**A38 Derby Junctions**  
**TR010022**

**8.91 Applicant's Responses to Information  
or Submissions Received by Deadline 8**

**Applicant's Responses to Information or Submissions  
Received by Deadline 8**

<b>Regulation Number</b>	Rule 8(1)(k)
<b>Planning Inspectorate Scheme Reference</b>	TR010022
<b>Document Reference</b>	TR010022/APP/8.91
<b>Author</b>	A38 Derby Junctions Project Team, Highways England

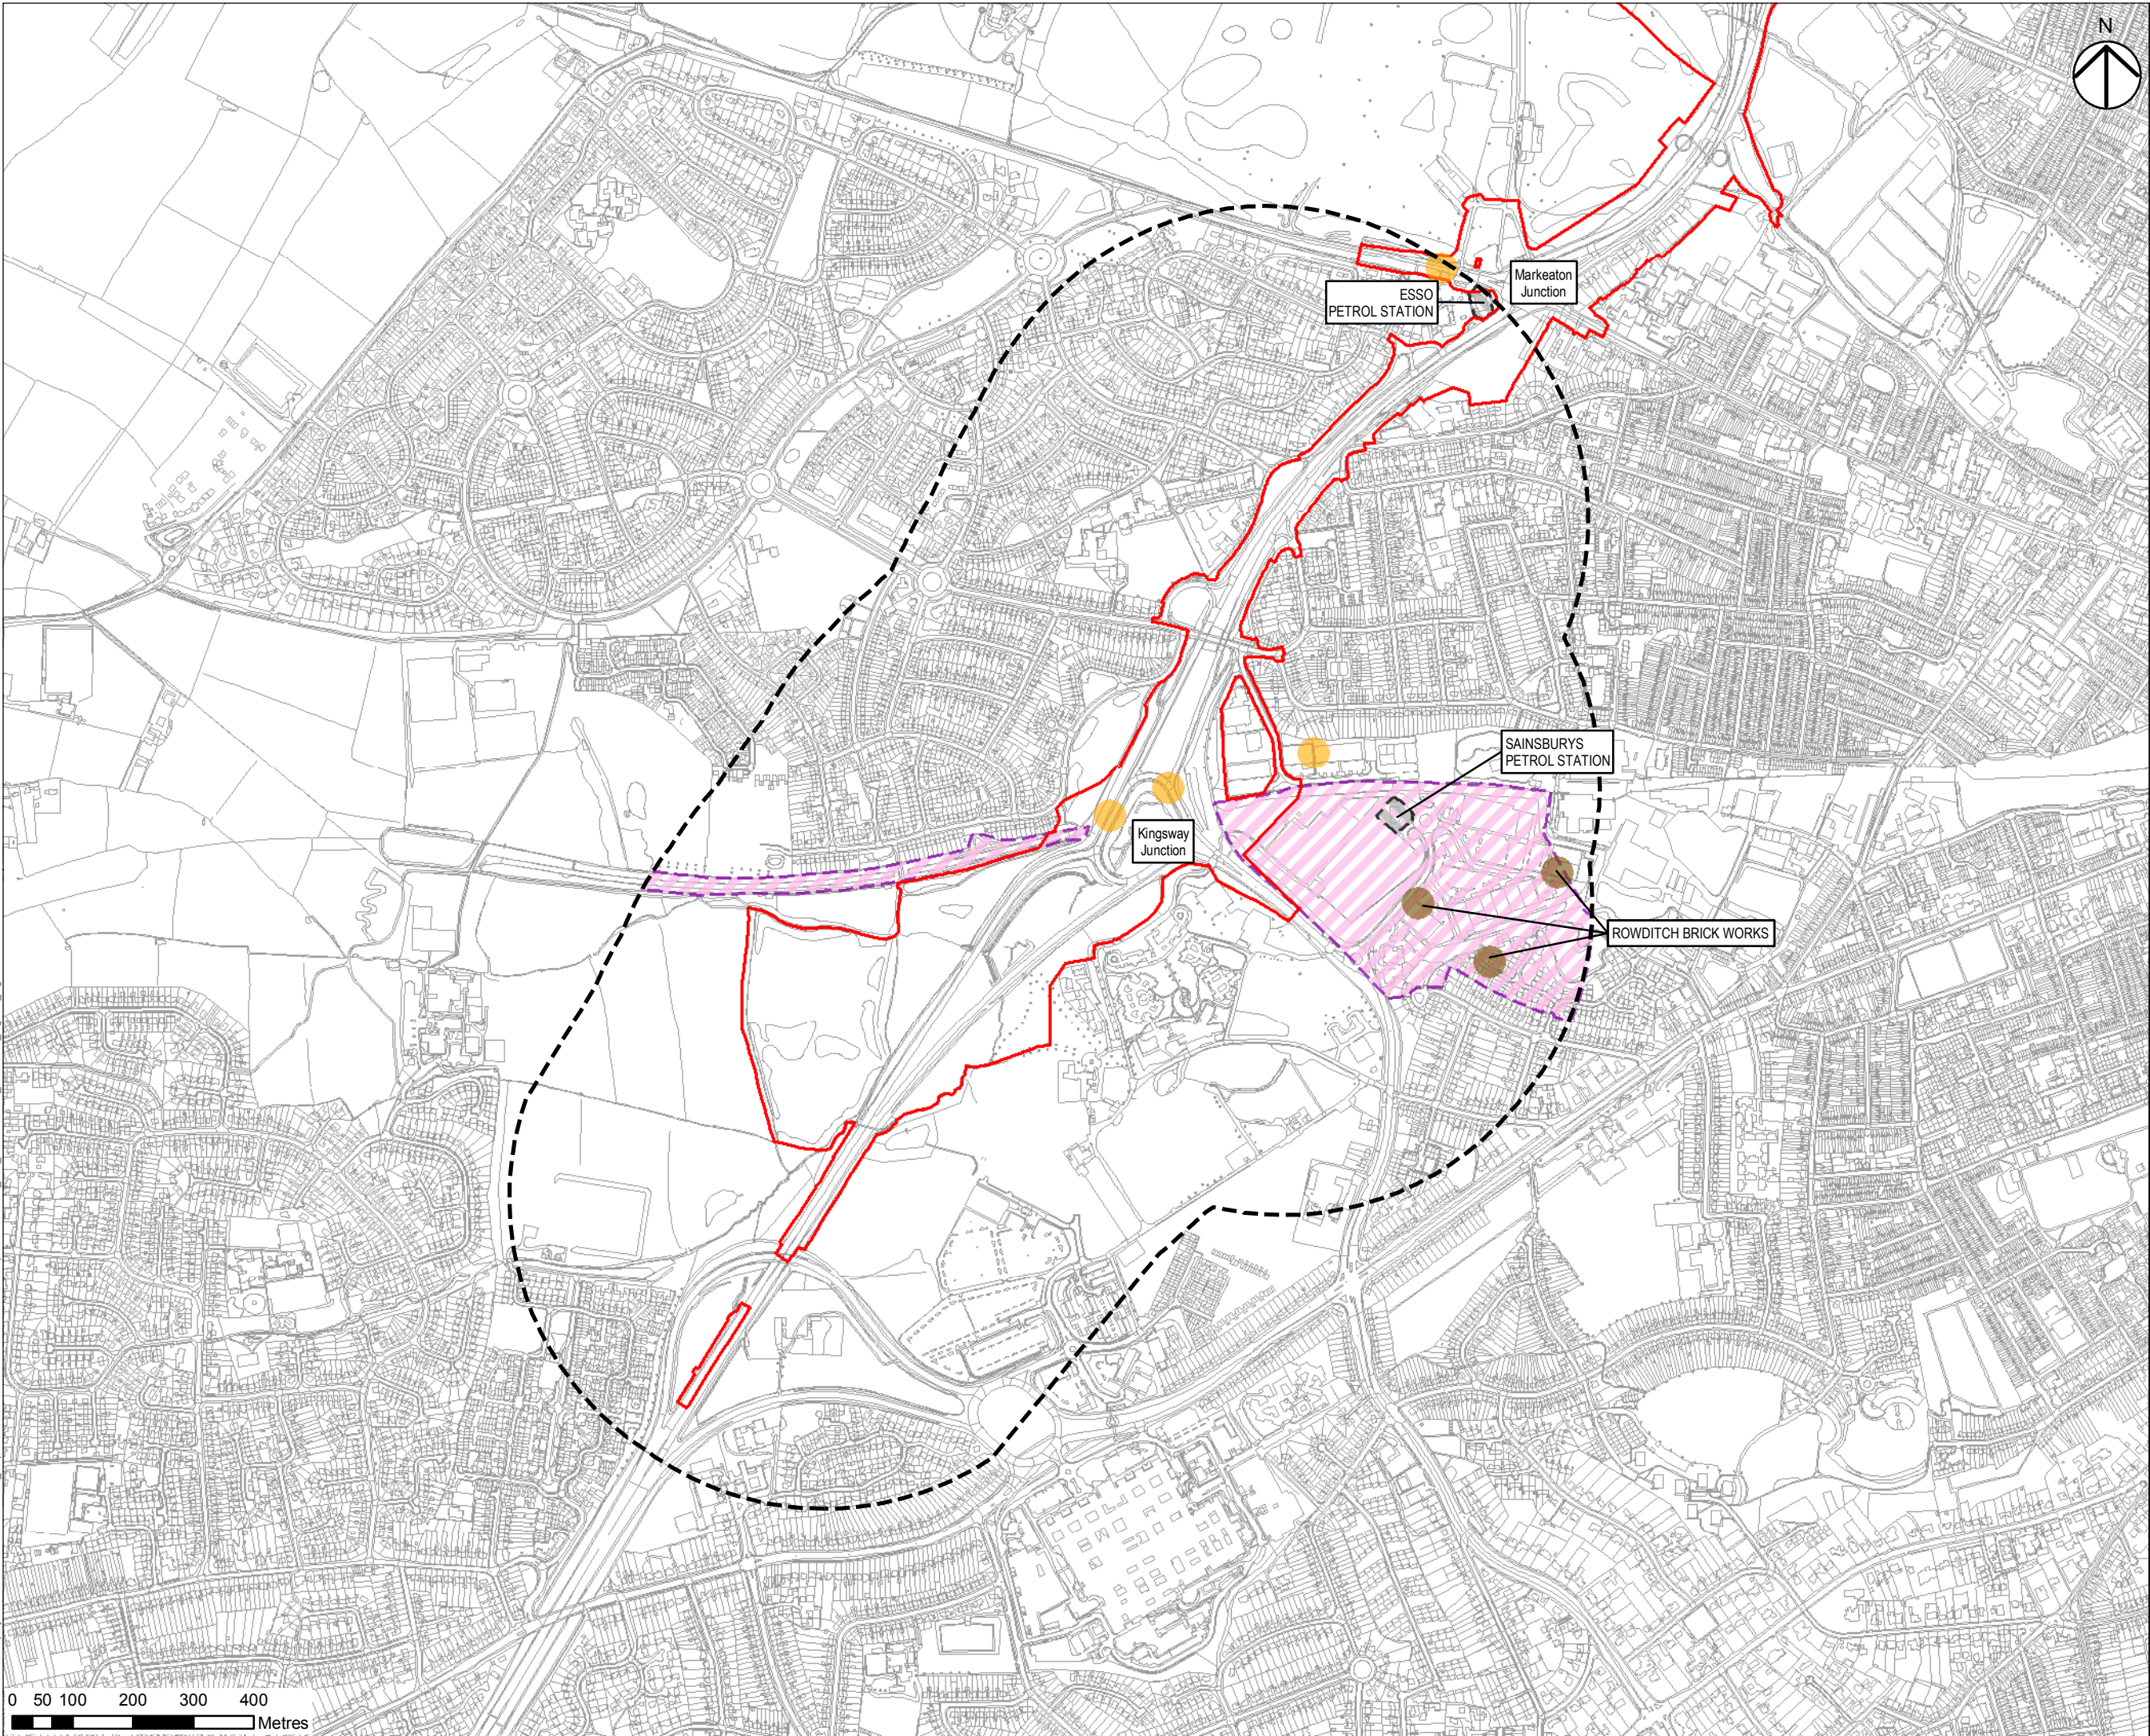
Source	Comment	Applicant's Response
	<p>Q46 HE response to Q13 – HE has acknowledged that traffic and pollution will be increased with the schemes. “emissions overall would increase” As the full account of the effects of HE schemes - on other roads with induced traffic, for example - have not been evaluated, how can HE claim a 'long term and sustainable benefit to the environment'?</p>	<p>It is thought that this relates to FOE question Q5 rather than Q13 which was related to fuel duty revenues and the claim made that it is in HE's interest to increase the number of car journeys. Our response to Q13 was that Highways England is funded by central government and has no say in fuel duty rate, how it is raised or how this revenue is used. Our response to Q5 stated that <i>“With regard to air quality, the air quality effects of the Scheme have been investigated and reported in ES Chapter 5: Air Quality [APP-043]. Overall, operation of the Scheme is expected to improve air quality slightly with a greater number of properties expected to have an improvement rather than a deterioration. Emissions overall would increase slightly with increased emissions from increased traffic on the A38 but properties tend to be located further from the A38 than from roads within the city. Emissions in future years will be lower than currently as cleaner vehicles penetrate the vehicle fleet so the slight increase in emissions due to the Scheme is offset against a long term trend of decreasing emissions”</i>.</p> <p>The air quality assessment reported in the ES Chapter 5: Air Quality [APP-043] considered air quality effects across a wide geographical area taking account of changes in traffic flow patterns as a result of the Scheme. Traffic flows were modelled over a large area that included all of Derby, the M1 to the east, the A50 to the south and M1 junction 28 to</p>

Source	Comment	Applicant's Response
		<p>the north (refer to Figure 3.1 in Transport Assessment Report [APP-254]) so that increases and decreases in flows across the traffic model study area could be assessed. Traffic flows beyond this area will not change.</p> <p>It is beyond the scope of the Scheme assessment and Examination to evaluate and comment upon the air quality effects of all Highway England schemes, although as detailed in the HE Strategic Business Plan 2015 – 2020 HE <i>“will continue to ensure our activities do not adversely impact the environment and in future will further reduce the impact of our activities to ensure a long term and sustainable benefit to the environment and the communities we serve”</i>.</p>
	<p>Q47 HE response to Q16 -Proposals at Kingsway Junction include wetland habitats, Have calculations been made as to how much methane from the uncapped Kingsway landfill, will be emitted through the water?</p>	<p>As detailed in the HE response to FOE Q16 [REP7-007], the Scheme proposals at Kingsway junction include flood storage areas that will provide wetland habitats. As detailed in the Environmental Masterplan 2.12A [APP-068], two flood storage area/ wetland features will be located adjacent to Bramble Brook on the Kingsway hospital site, whilst one a flood storage area/ wetland feature will be located to the north of the junction positioned between the mainline and the northbound off-slip. None of these flood storage areas/ wetland features are located over areas of former landfilling (refer to ES Figure 10.1 [APP-137]).</p>
